Attn: David Henderson
Re: 2273 Home Remodel
2273 74th AVE SE, Mercer Island
Structural Correction Comment Response

The following is the response to structural correction comments for the above referenced project dated on April 3rd, 2024.

CHECKED: KWC
DATE: 01-08-2024
SHEET NO:
S1.2

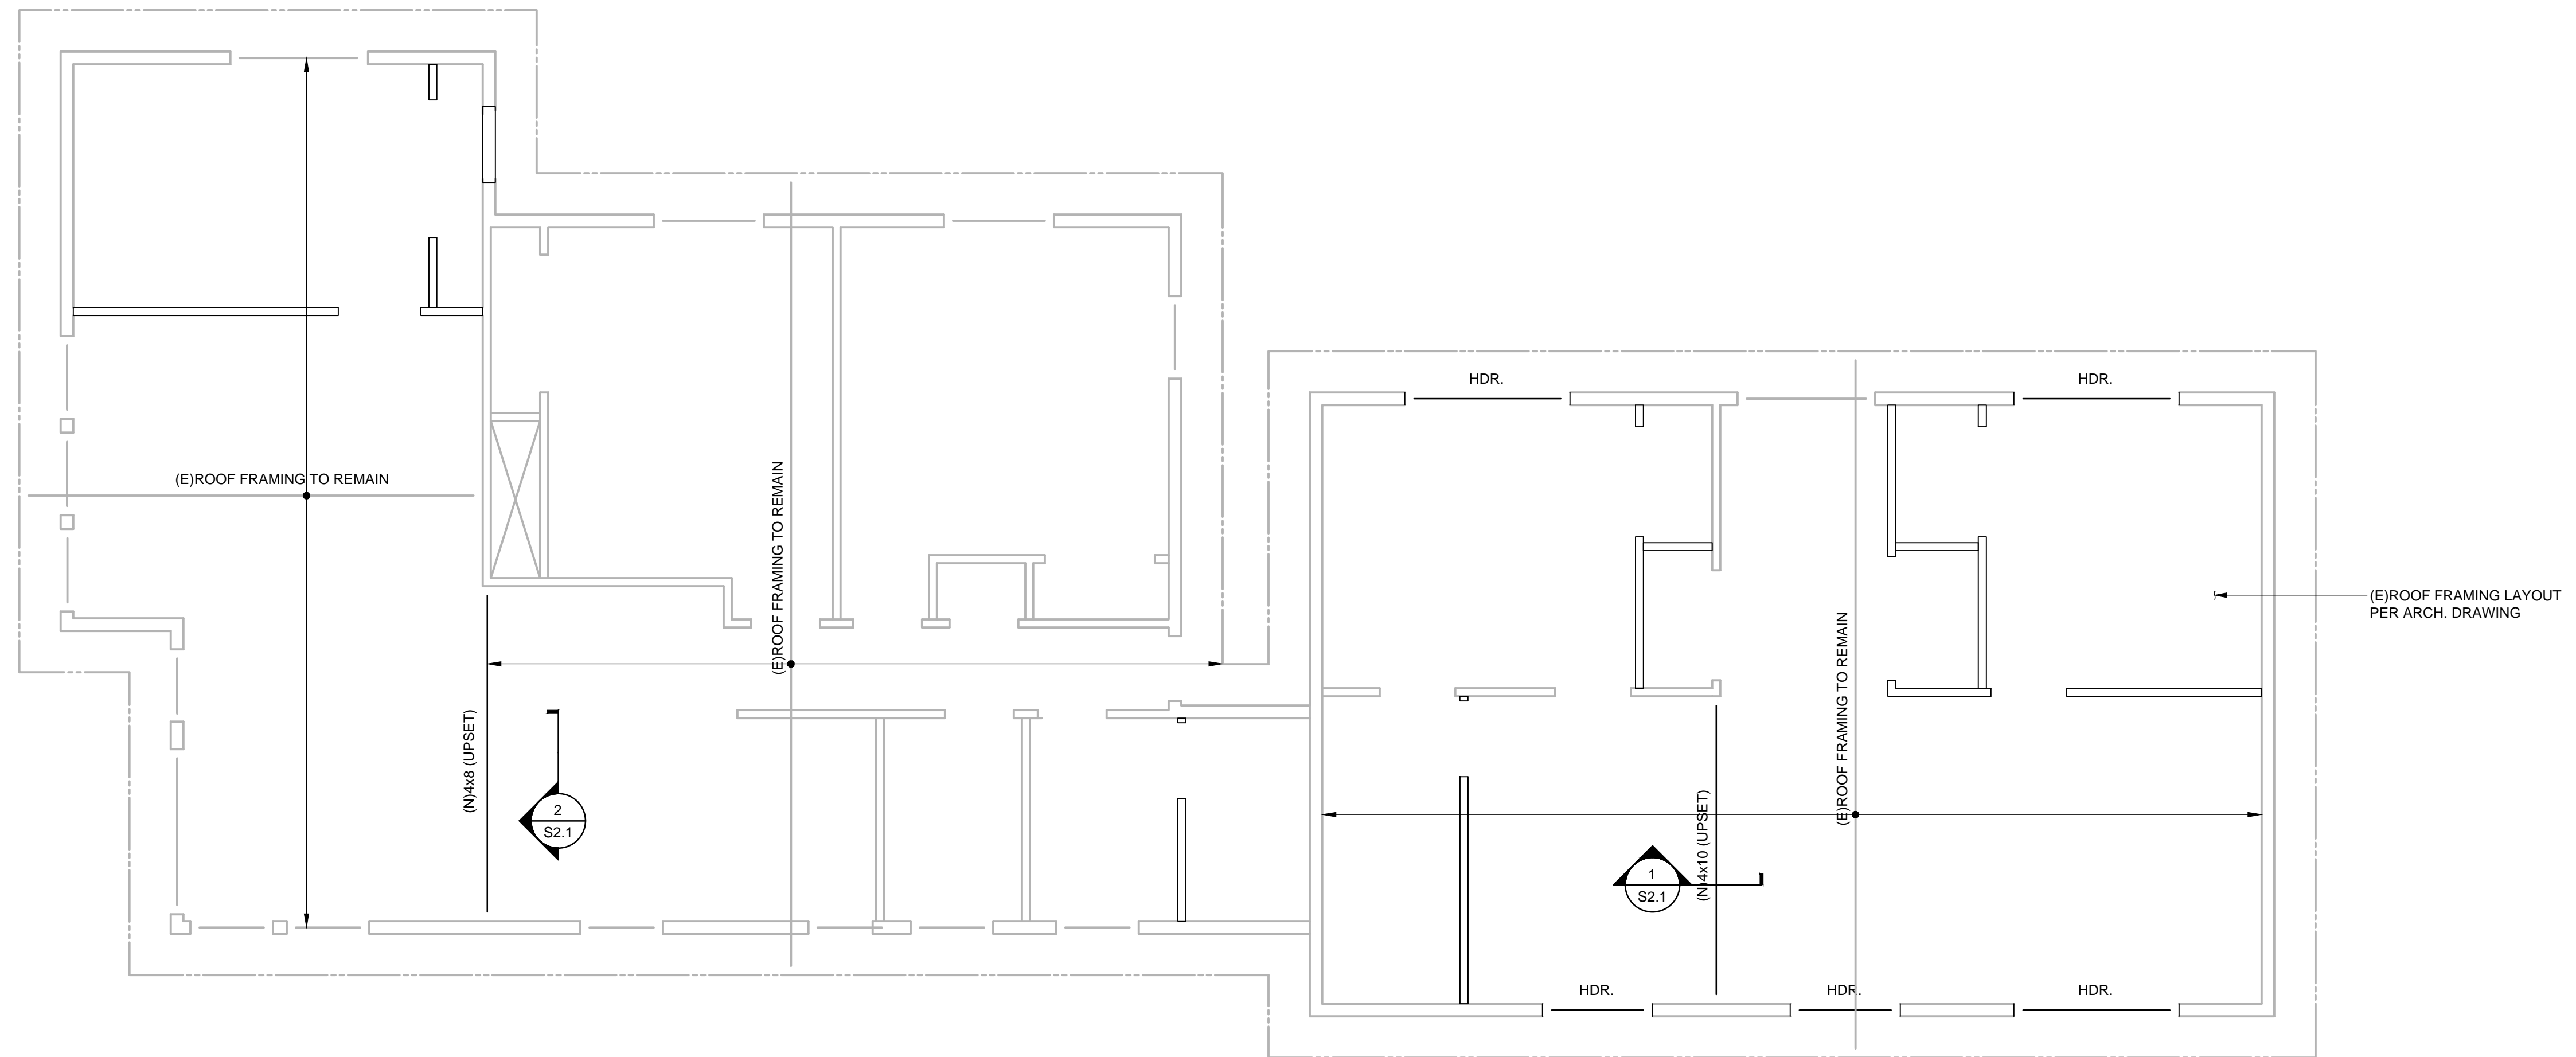
Sheet S1.2 Please Show all new point loads and footings. VIF is not approved. Please provide all existing footing sizes and all new proposed footing(s), any doweling details etc.. Please show and provide all support columns for new beams including sizing and any fastening schedule for multi-ply built columns (slenderness) as needed per EOR design.

Response: Please see revised structural drawing. New beam is proposed to be supported on (2)2x built-up post, see Section 3/S2.1. Built-up post to be spliced per section 7/S2.1. Additional notes are now added on plan drawing. Please kindly note that the proposed new 6x10 end support loading is around 2.8 Kips (ASD) max, the loading is considered to be low for concrete slab-on-grade set on soil, using the Shentu method to estimate the allowable bearing pressure accounting concrete strength and elasticity, with 4" concrete slab-on-grade, a point load of 11.5 Kips (ASD) (Factor of Safety = 3.0) would be acceptable, representing a DCR of $2.8/11.5 = 24\%$ capacity utilization. It is my engineering judgement that existing exterior footing and slab-on-grade are acceptable to provide support of the new beam loading, without any retrofit requirement. Existing footing size will not be required to be verified, as any footing size larger than 4" will be structurally acceptable. Note that existing stem wall thickness is at 6" minimum.
